Location of Construction:		Owner:		Phone:	
Owner Address:		Leasee/Buyer's Name:		Phone:	
Contractor Name:		Address:		Phone:	
Past Use:		Proposed Use:		COST OF WORK: \$	
				PERMIT FEE: \$	
				FIRE DEPT. <input type="checkbox"/> Approved <input type="checkbox"/> Denied	
				INSPECTION: Use Group: Type:	
		Signature:		Signature:	
Proposed Project Description:		PEDESTRIAN ACTIVITIES DISTRICT (P.U.D.)			
		Action: Approved <input type="checkbox"/>			
		Approved with Conditions: <input type="checkbox"/>			
		Denied <input type="checkbox"/>			
		Signature:		Date:	
Permit Taken By:		Date Applied For:

PERMIT ISSUED
Permit Issued:
JUN 2 1 1996
CITY OF PORTLAND

RE: 3 Cherry Street, Portland, ME - 065-A-007

RE: Postolache Residential Property at 3 Cherry Street, Portland, ME

TOLERANCES EXCEPT AS NOTED	REVISIONS			1 ST FLOOR PLAN		
	NO	DATE	BY	1-3 CHERRY ST		MATERIAL
DECIMAL ±	1			DRAWN BY S.C. AMBIANI	SCALE 1:48	DRAWING NO 01
FRACTIONAL ±	2					
ANGULAR ±	3			CHECKED	DATE	
	4			TRACED	APPROVED	
	5

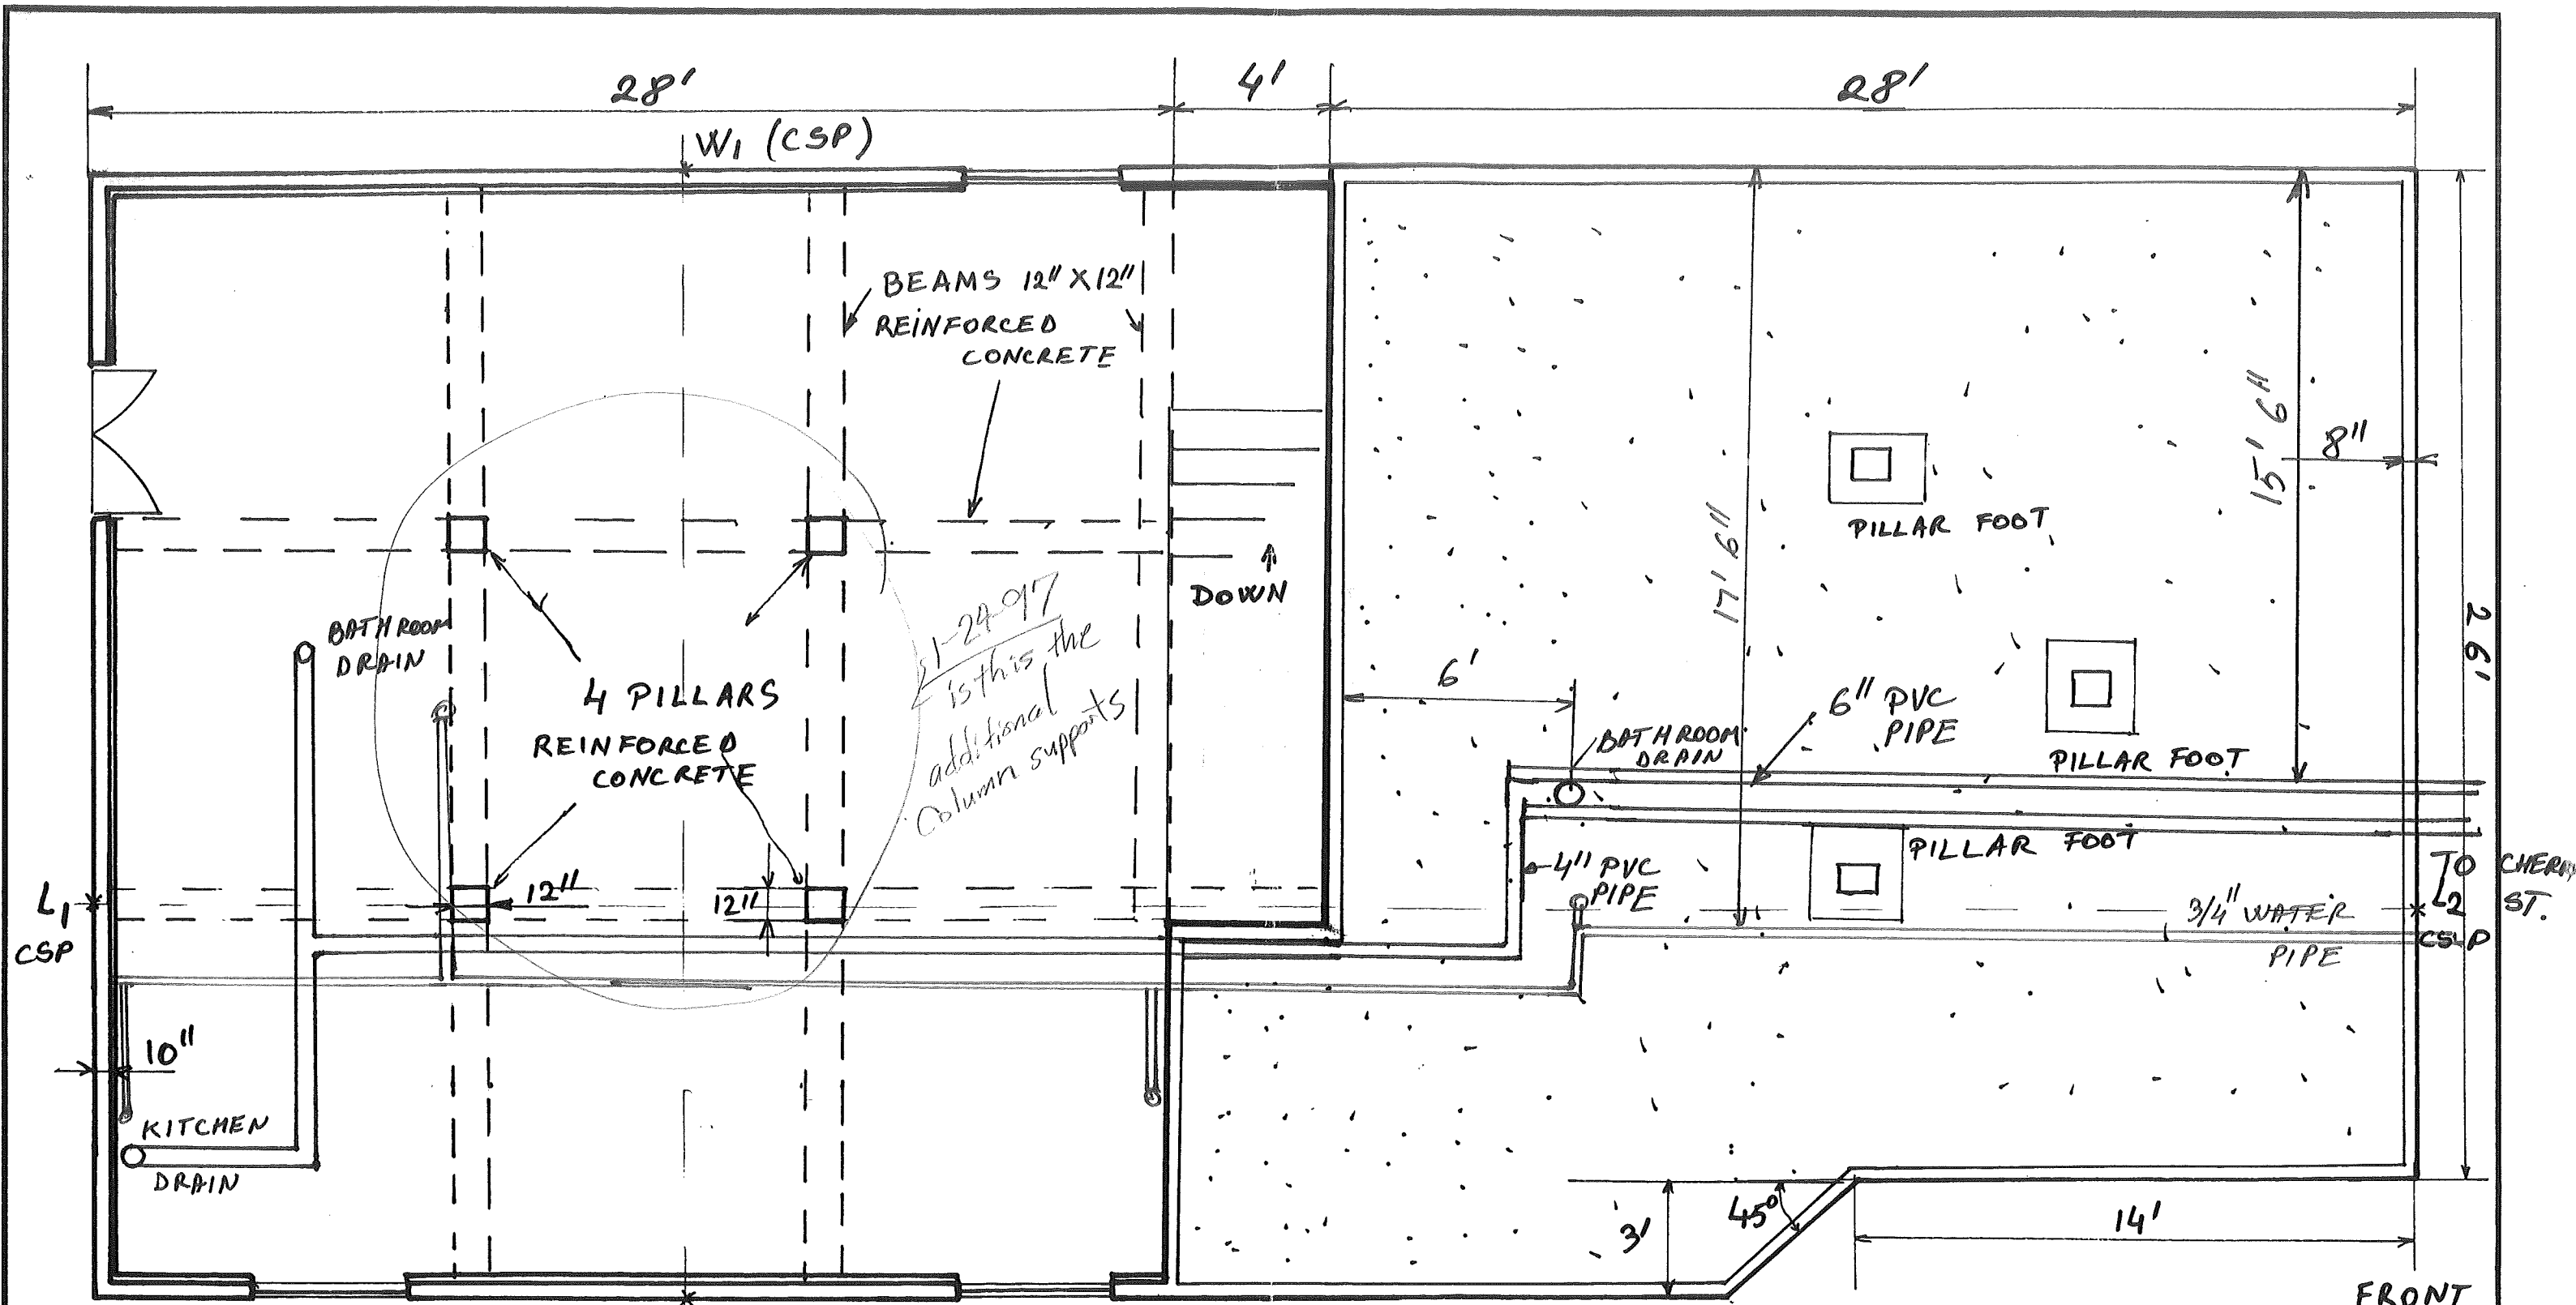
Secondly, we conducted a structural analysis of the floor slab and found it to be under capacity with respect to the 1996 BOCA Building Code and ACI 318 Concrete Construction Codes. Based upon this analysis, we designed four additional column supports to be placed beneath the existing composite steel sections placed in the slab. We have attached a sketch showing the placement of these columns. After the columns have been placed in accordance with the attached plan, the floor slab should be sufficient to support a live load of 30 psf given that its overall influence area is greater than 400 sf in accordance with the 1996 BOCA Building Code. Finally, we recommend that the second story floor slab be designed in accordance with the ACI and BOCA Building Codes. Should you have any questions, please don't hesitate to contact me.

3 PROPOSED  
PARKING  
SPACES

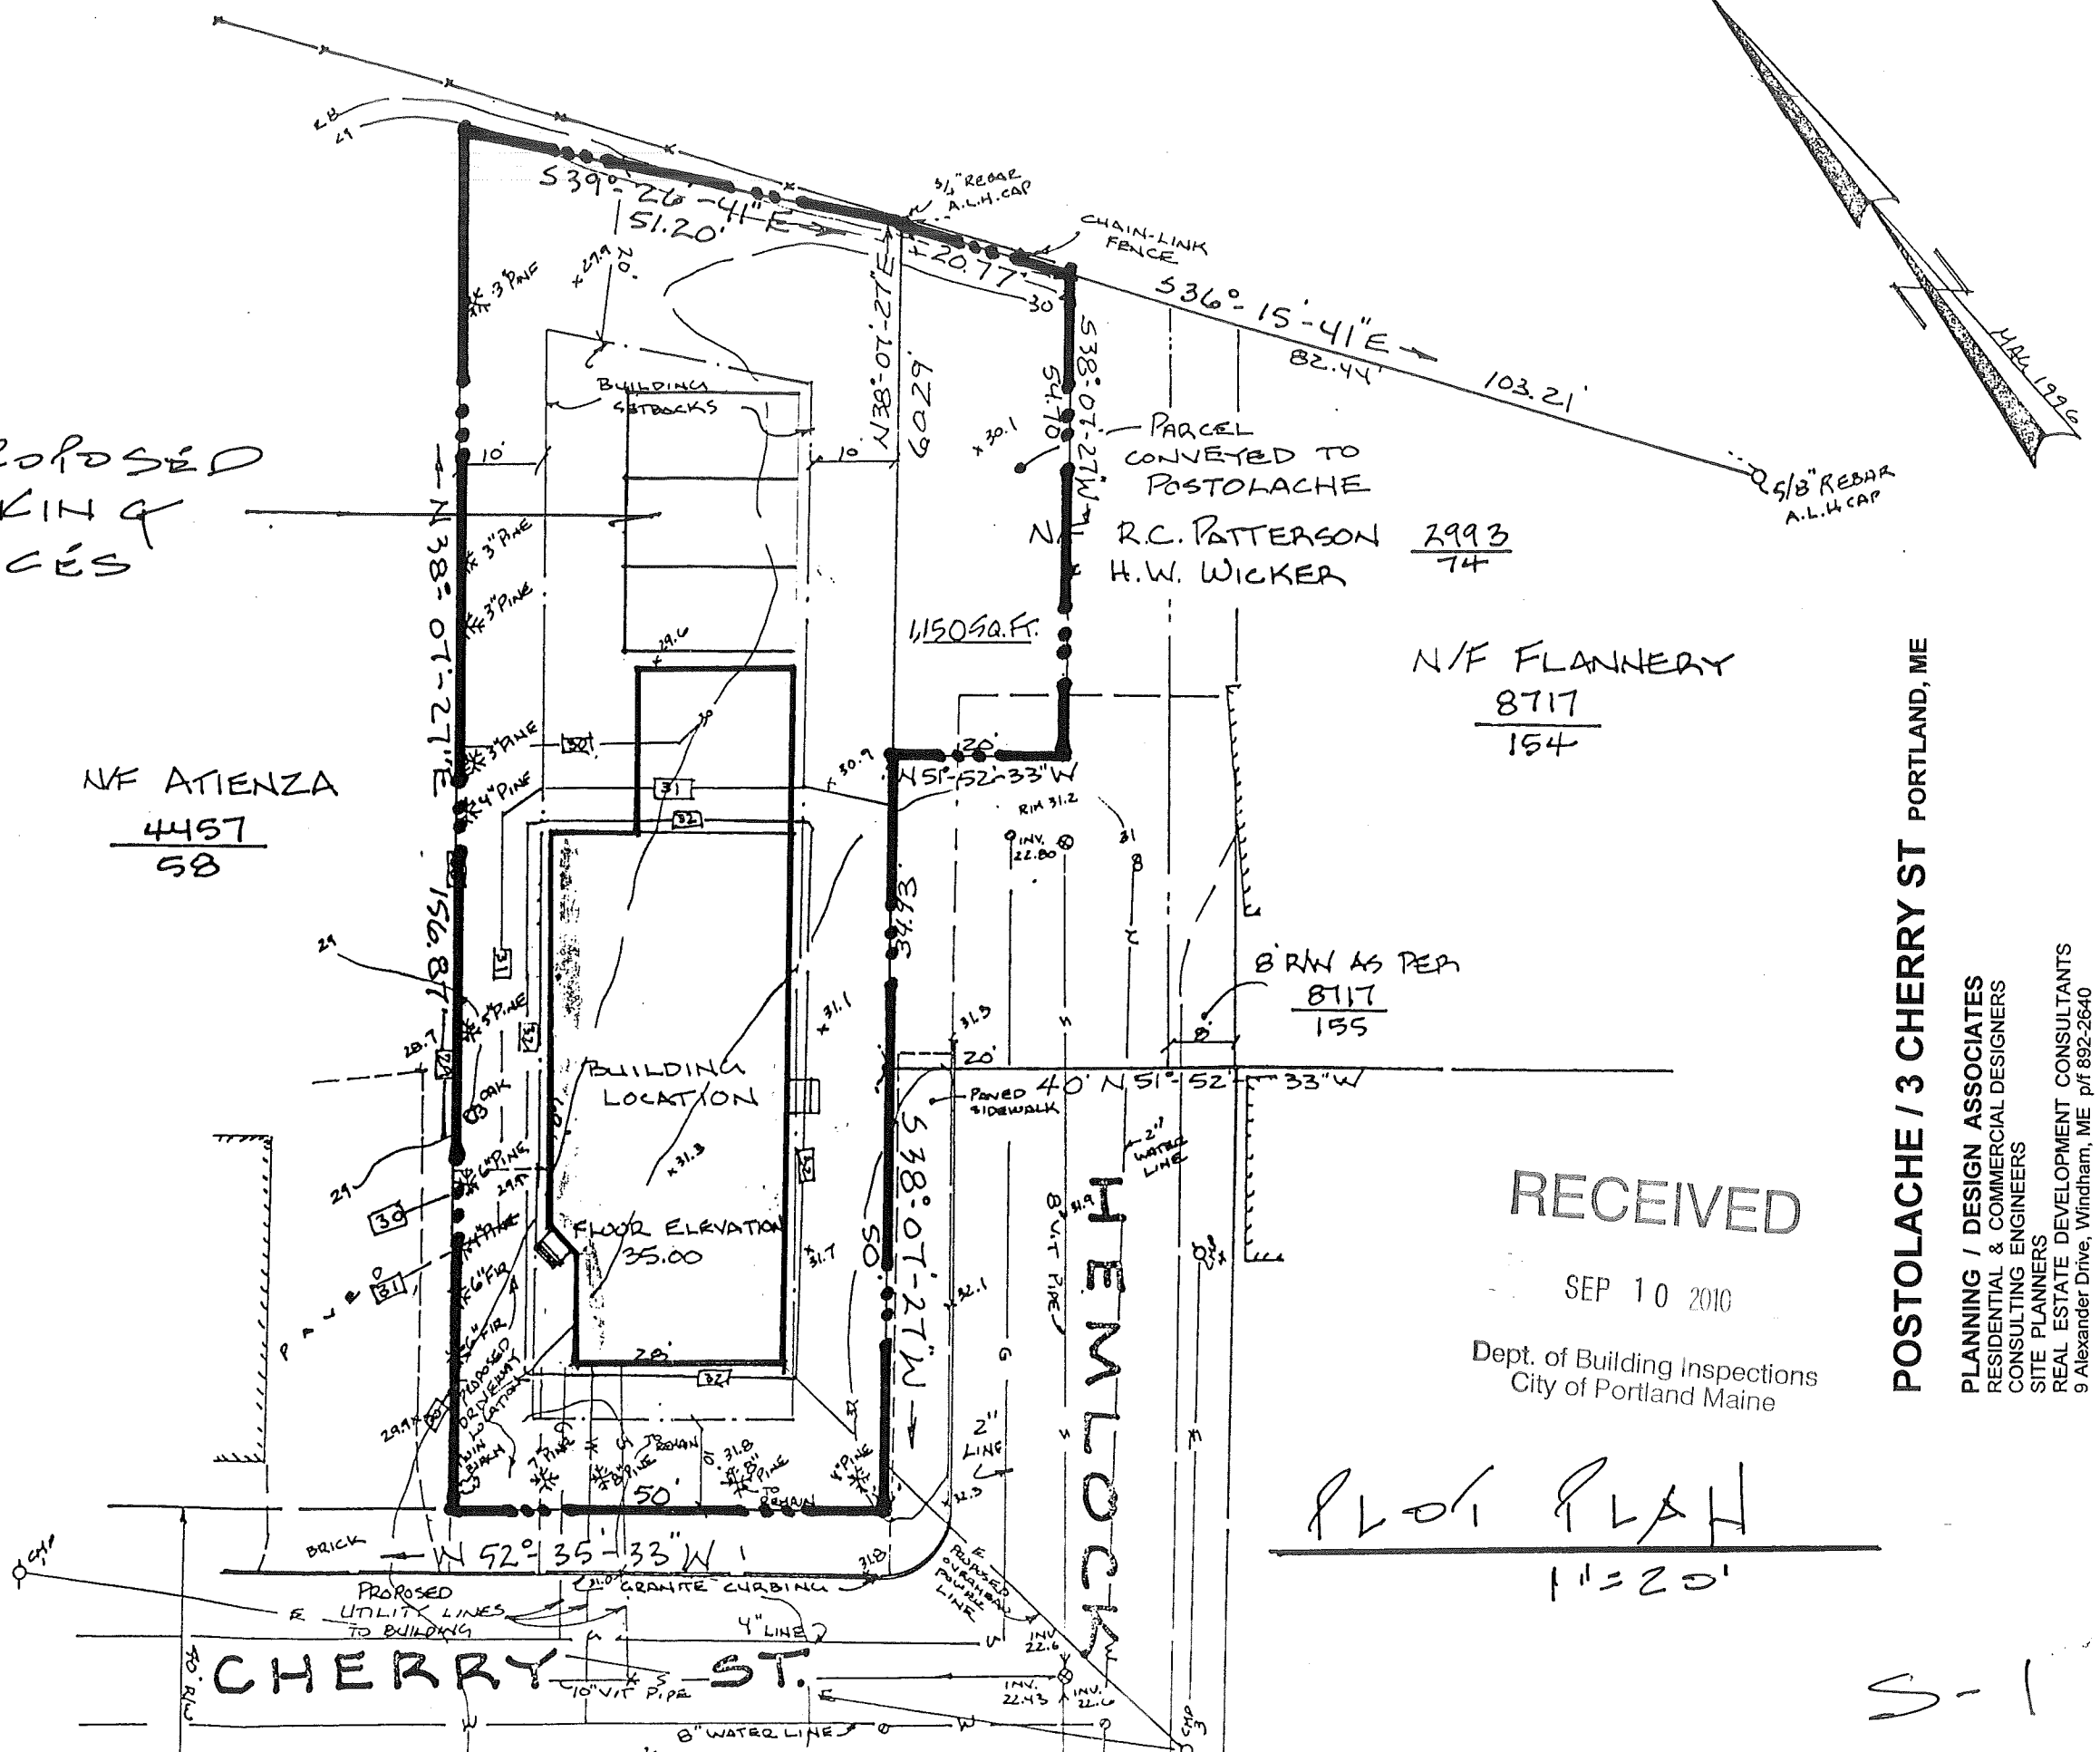
I am in the process of reviewing your new single family dwelling permit for zoning requirements. My recent phone calls to you were not accepted. I am notifying you that I can not complete my review of your permit until you can show me two off- street parking spaces (9 x 19 each) as required by ordinance.

Your permit will be on hold until you can provide me with a revised plan showing these two spaces. If you have any questions regarding this matter, please do not hesitate to call.

6/17/96 — owner came in and showed me
Three parking spaces.
To check with Jeff Tarling RE: Trees that
are to be removed.
